Department of Planning and Environment

Subject: Exhibition – 104-116 Regent Street, Redfern - Student Accommodation (SSD-12618001)

EES has reviewed the flood assessment, Stormwater and Flooding Assessments for the project, provided as part of the EIS.

FIGURE 2
PROPOSED GROUND FLOOR DESIGN
104-116 REGENT STREET

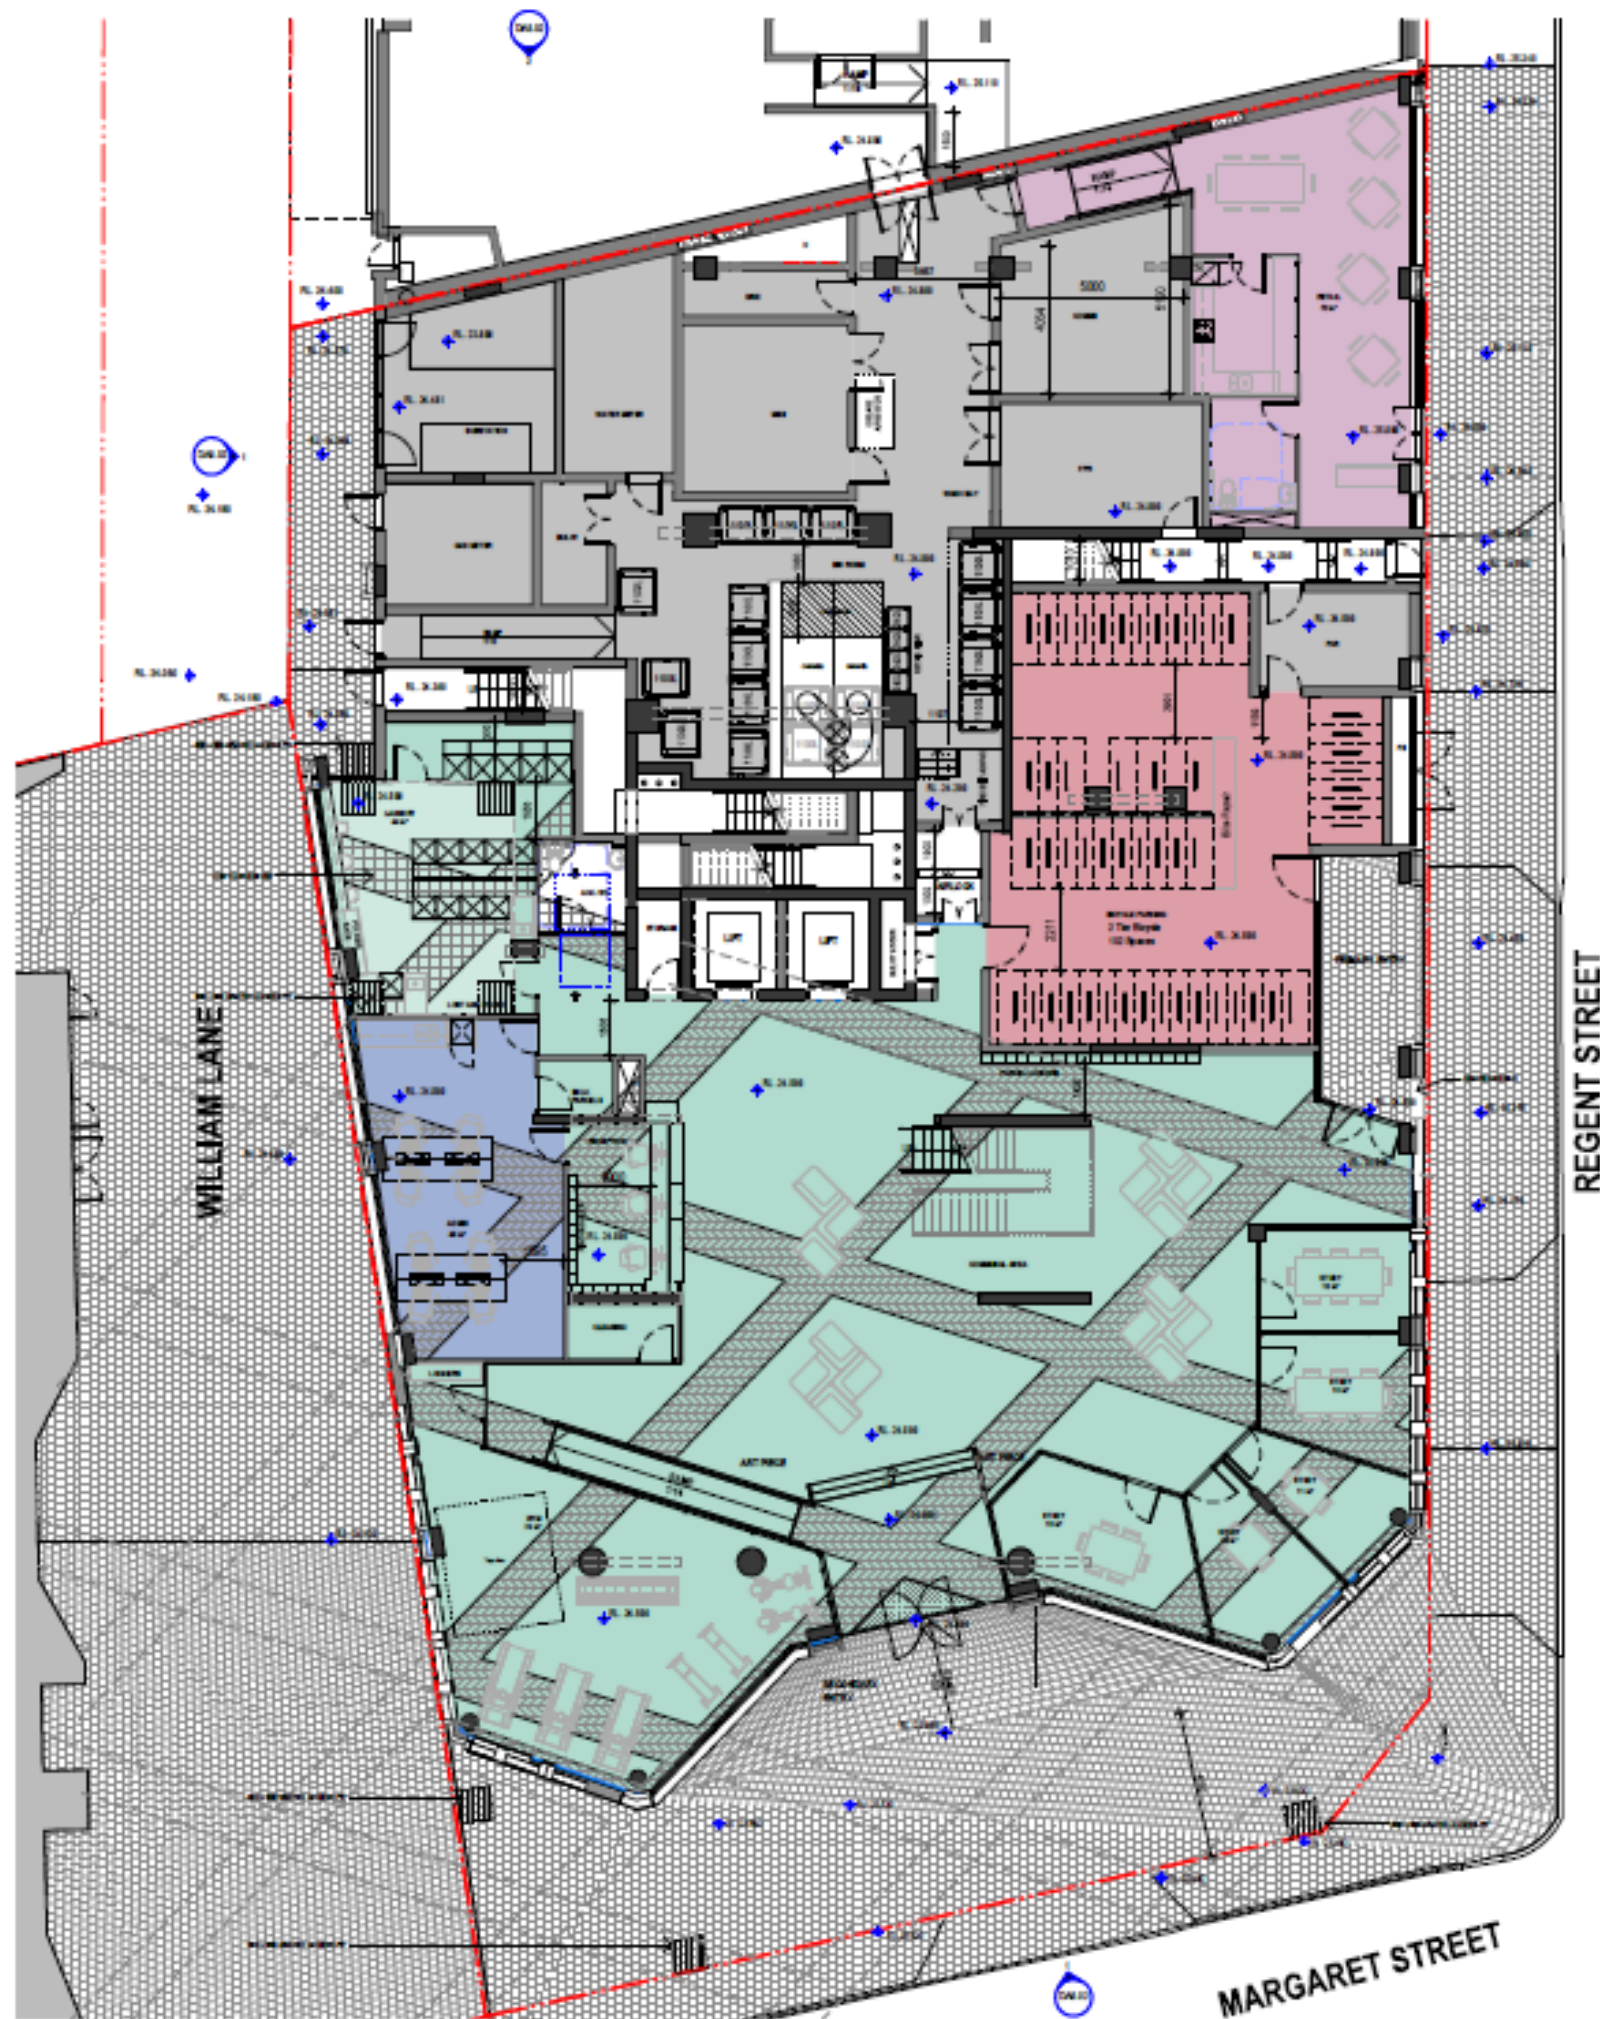
EES notes that the project site is surrounded by overland flows. The assessment should demonstrate that the relevant floor levels comply with *City of Sydney Development Control Plan 2012* by providing a table listing all relevant entry points or floor levels, the associated flood levels (1% AEP and PMF, possibly climate change) and any required freeboard.

FIGURE 3
PROPOSED DESIGN
13-23 GIBBONS STREET

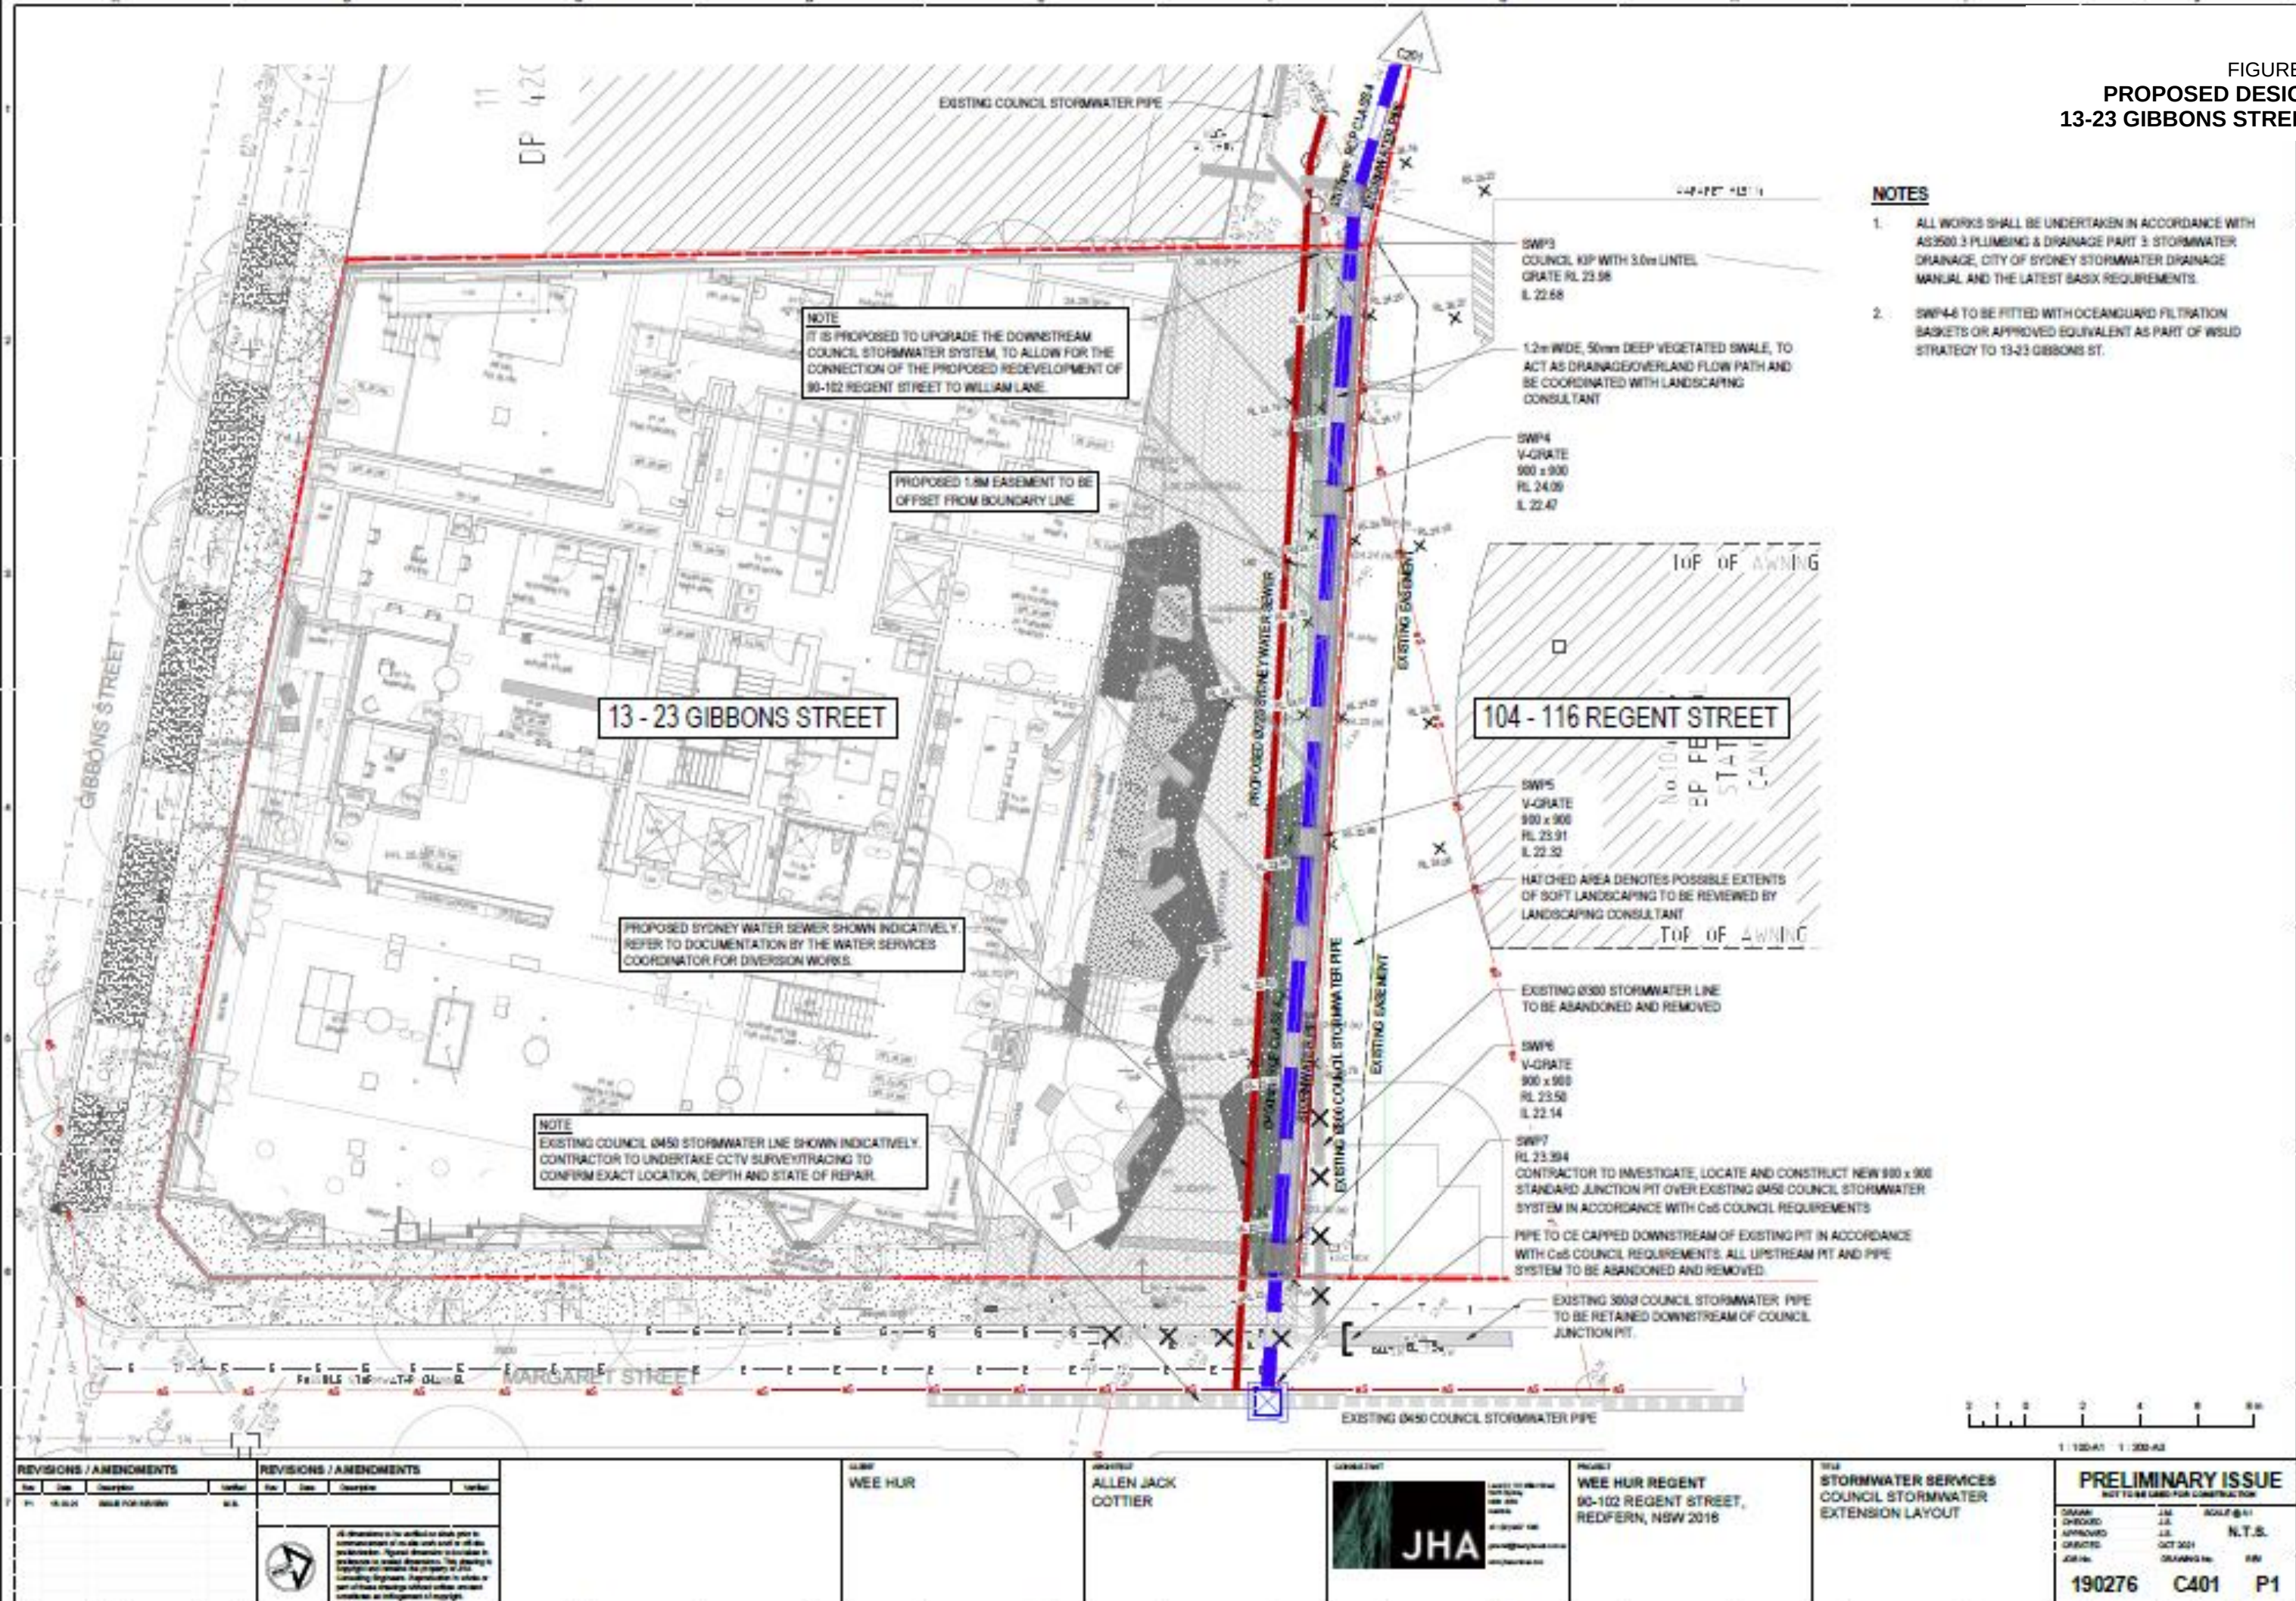
Flood risk management for the project relies on the construction of a new flow path in the adjacent lot (13-23 Gibbons Street). The conditions of approval should include provisions to ensure the flow path is completed and operational before occupation of the proposed development.
